CHARLOTTE - MECKLENBURG
PLANNING COMMISSION

DATE: January 30, 2003

SUBJECT: Administrative Approval for Petition No. 2002-62, J & J University Boulevard, LLC.

SCHEMATIC SITE PLAN

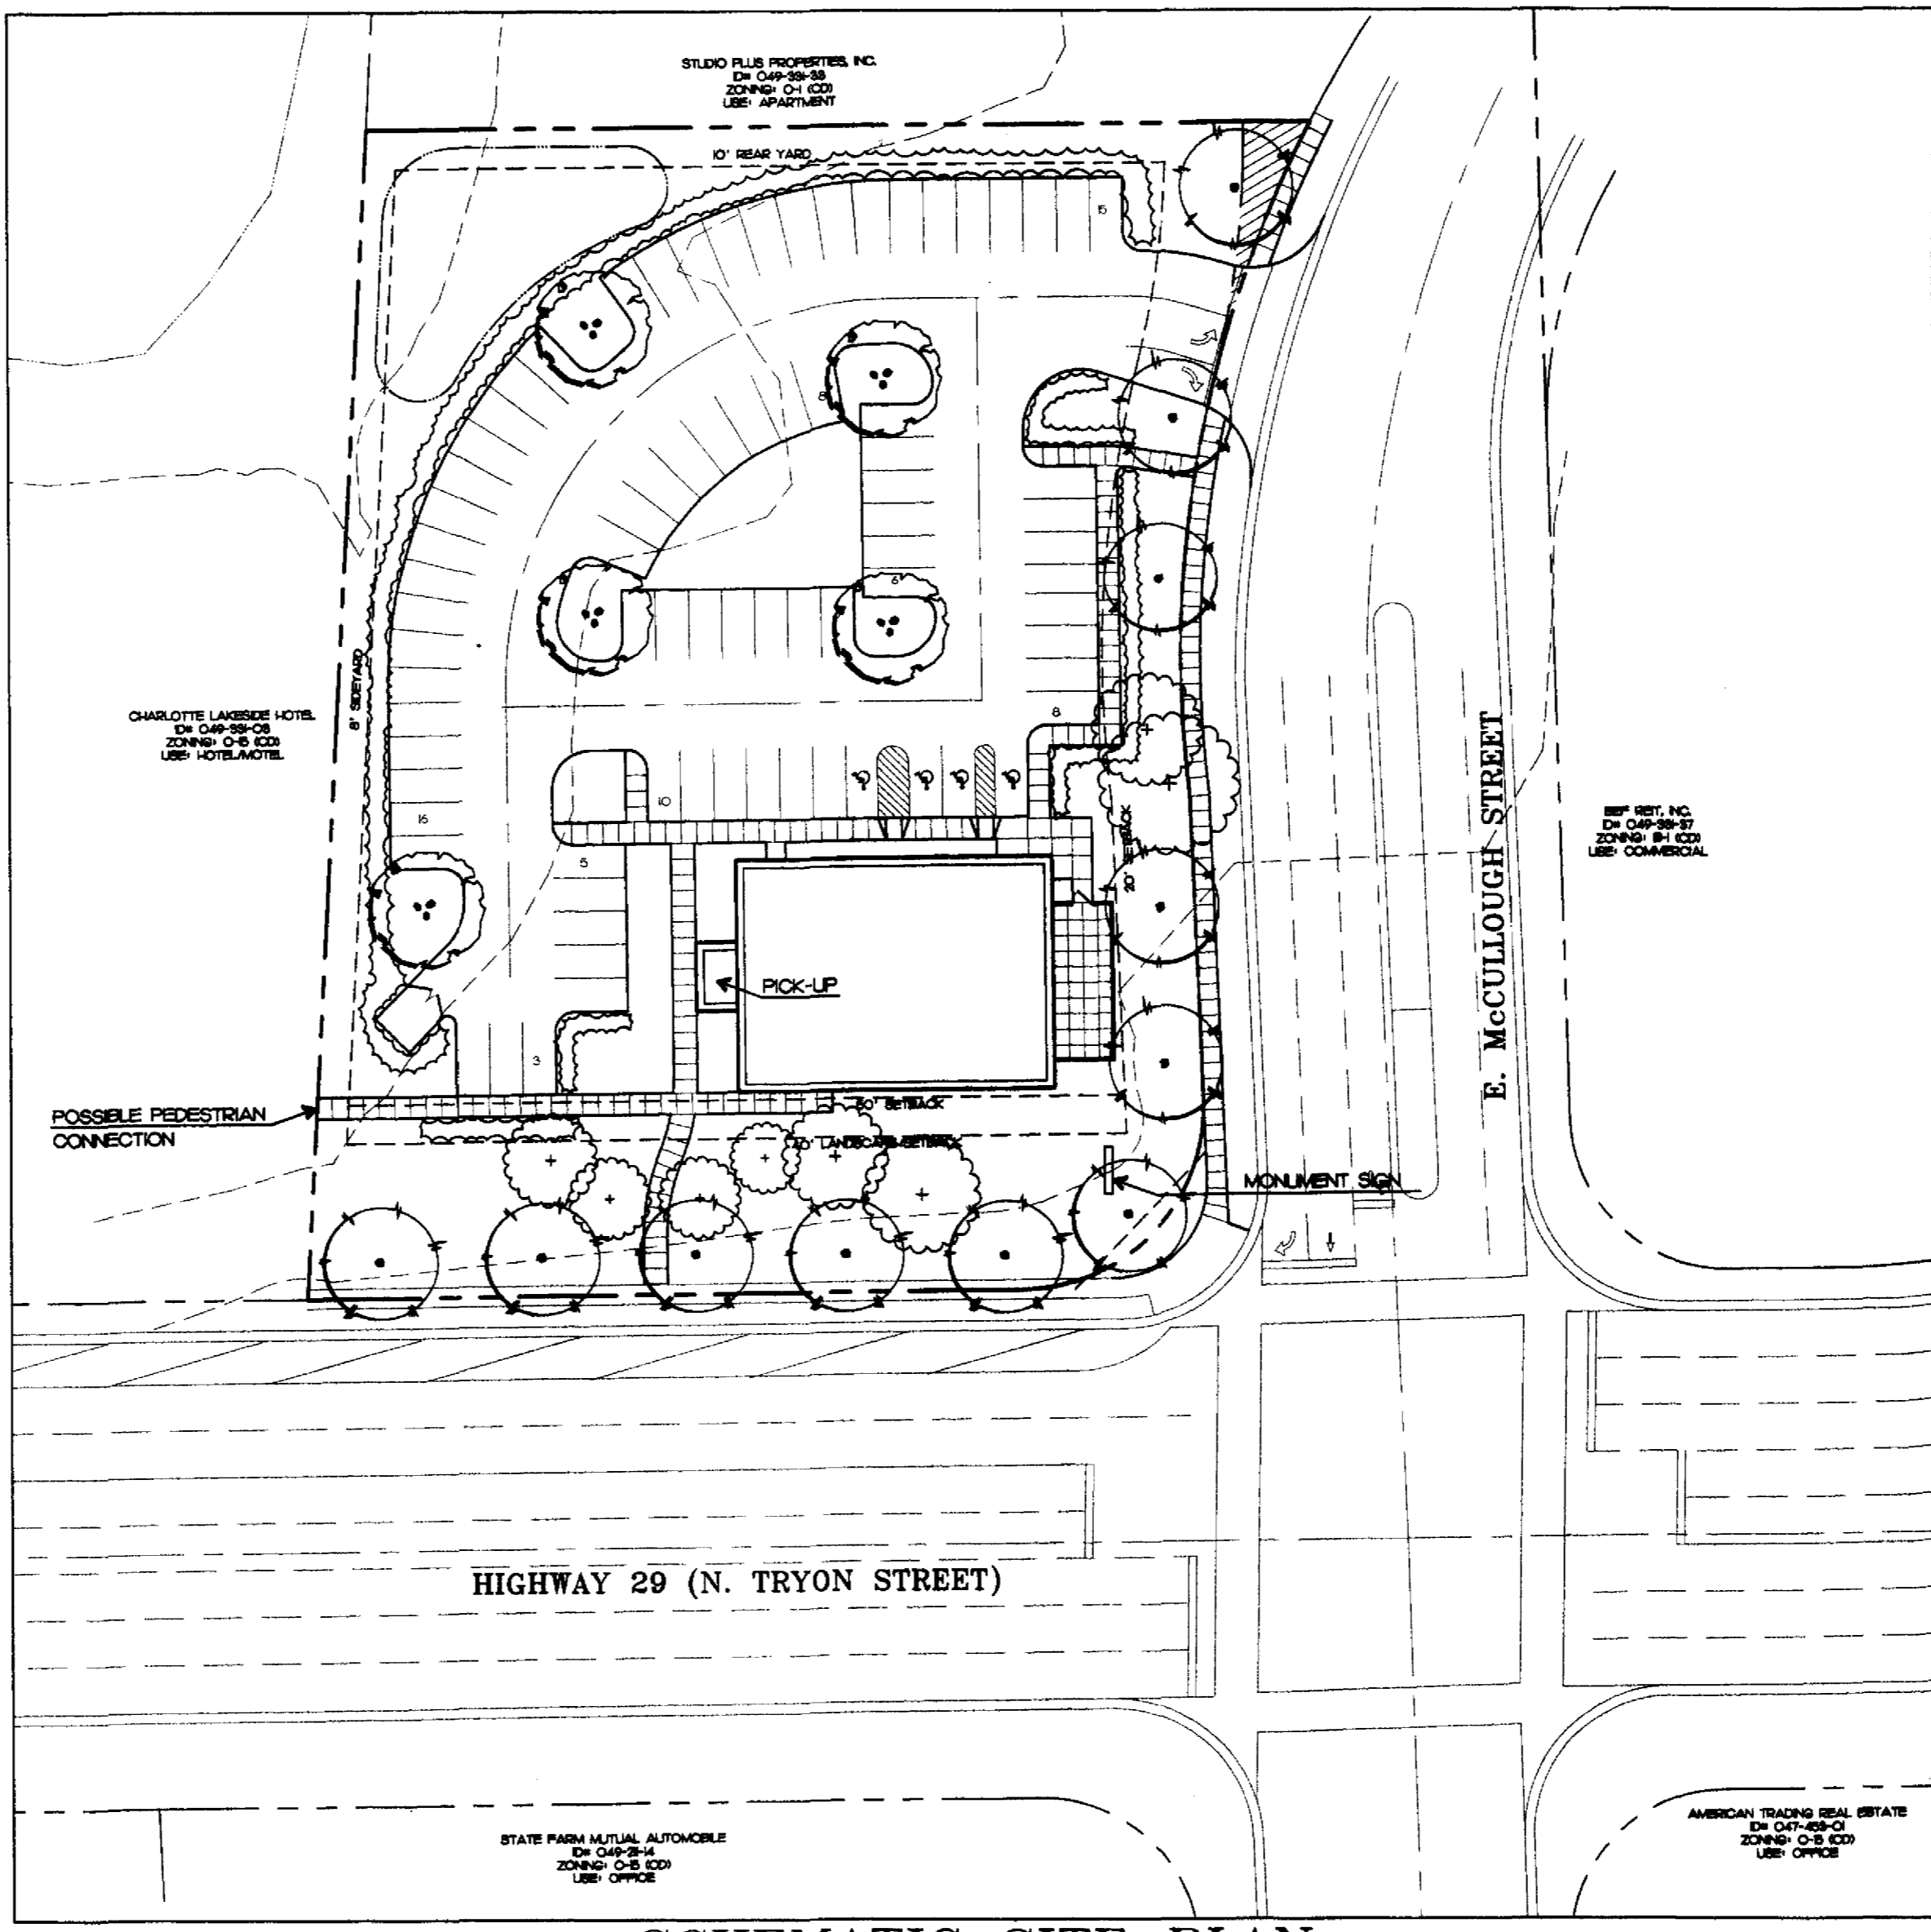
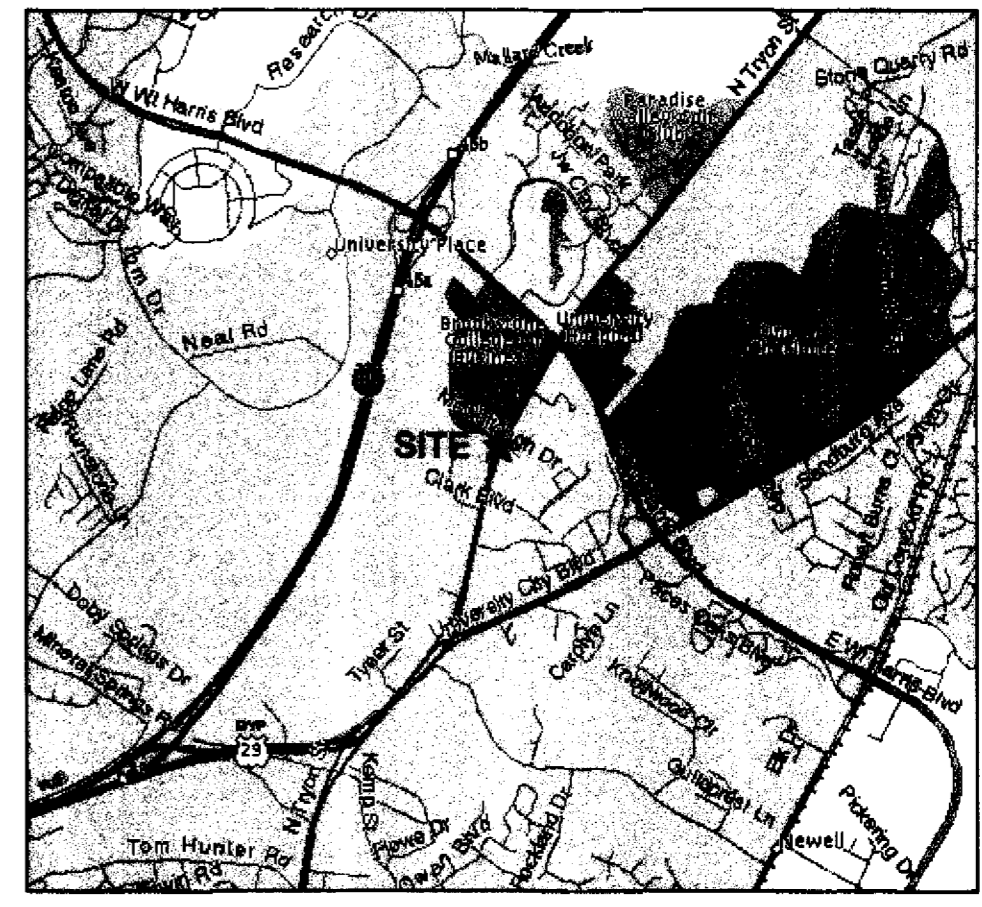
Attached is a revised site plan for the above rezoning petition. The plan has been revised to reduce the planting strip width along McCullough to 5-feet due to topographic conditions. Since this change is minor and does not alter the intent of the conditional plan, I am administratively approving this revised plan. Please use this revised plan when evaluating requests for building permits and certificates of occupancy.
